From: Adamantios Xanthoudidis <[REDACTED]>
Sent: 07 October 2026 09:55
To: Laura Mills
Cc: James Meachim
Subject: RE: R/148/26/PL - Visibility Splays

From: Adamantios Xanthoudidis <[REDACTED]>
Sent: 06 October 2026 14:29
To: Laura Mills <Laura.Mills@arun.gov.uk>
Subject: R/148/26/PL - Visibility Splays

Drawn AX	Checked AK	Date 21.01.26
Job No 7699	Drawing No PL-02	Rev -
Status

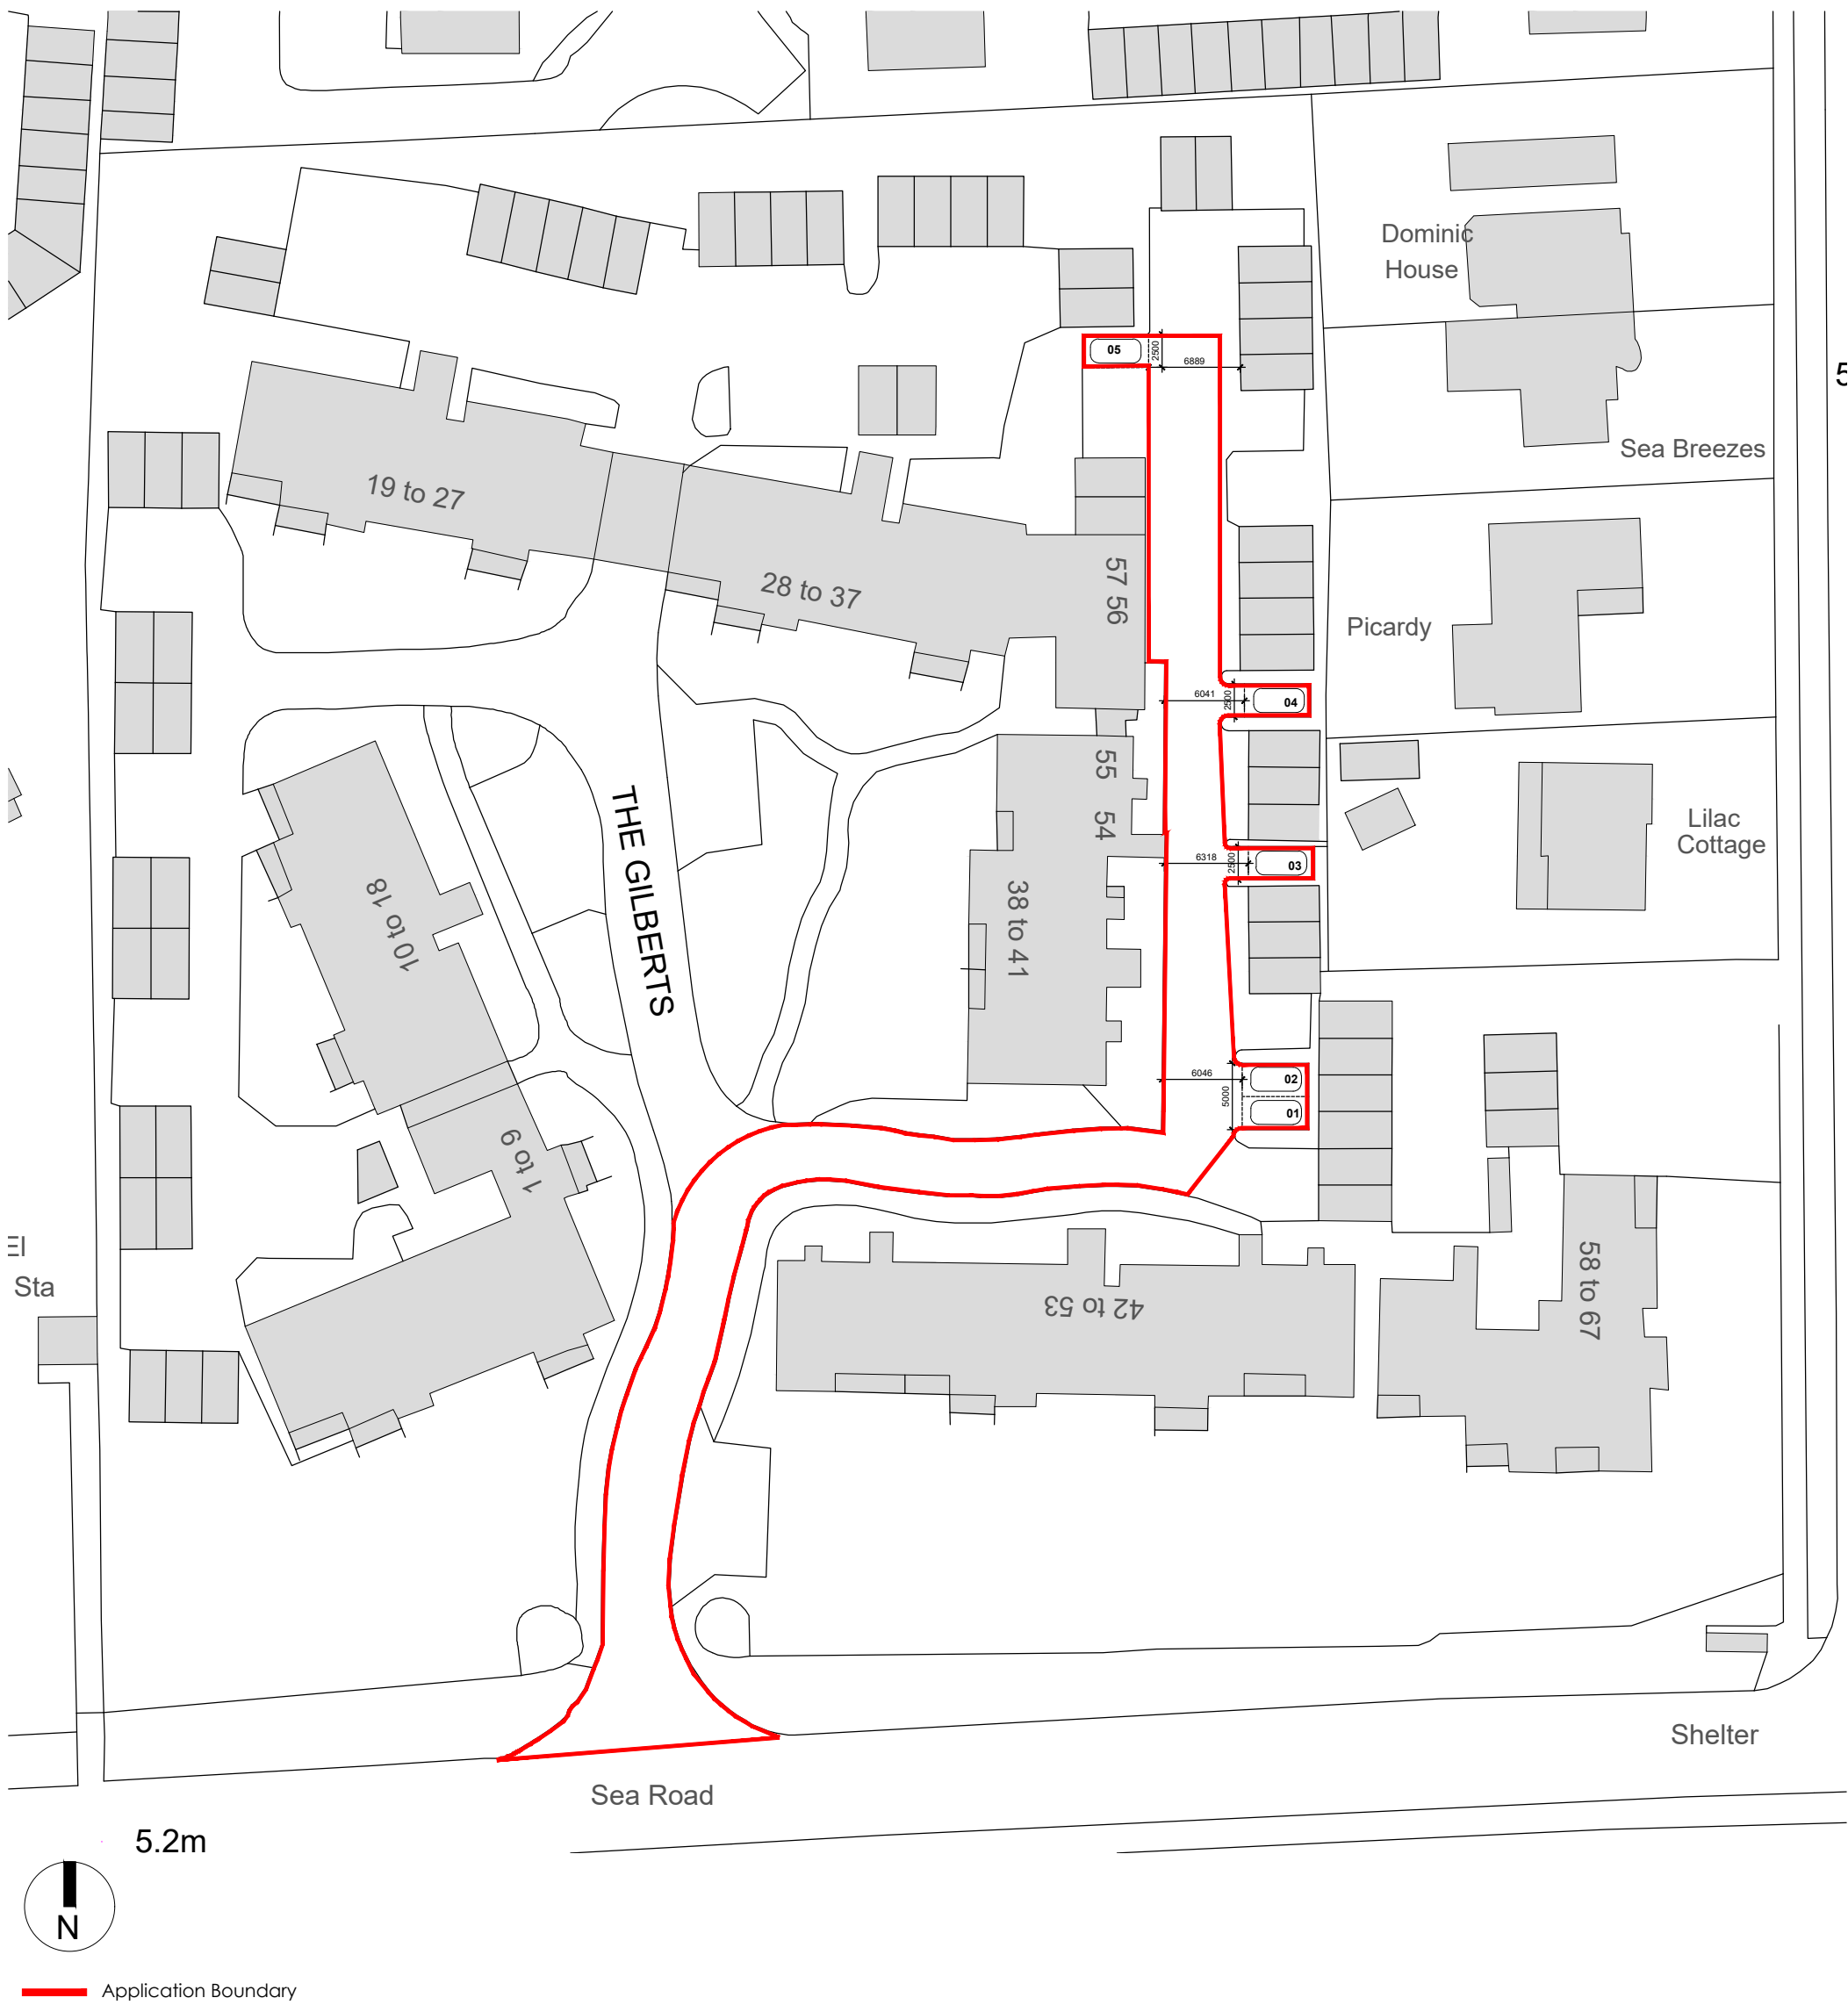
Apologies I did not make that clear, it was to show visibility splays from the parking spaces themselves. I can upload the below against the application as explanation if you want to leave the plans as they are?

Your letter states that visibility splays are required when creating a new vehicular access. As no new access is proposed, please could you confirm that visibility-splay information is not required for this application? If the request instead relates to the existing access, please clarify what information is required and why it is necessary for the proposed development.

Yes, please upload the below against the application as explanation and leave the submitted plans as they are.

The proposal does not include the creation of a new vehicular access onto the highway. The five additional parking spaces would be served by the existing access (via Sea Road) and internal circulation route, which would remain unchanged. This is shown on the submitted proposed and existing site plans, drawings 7699-PL02 & 7699-PL03, and is also stated in the application information.
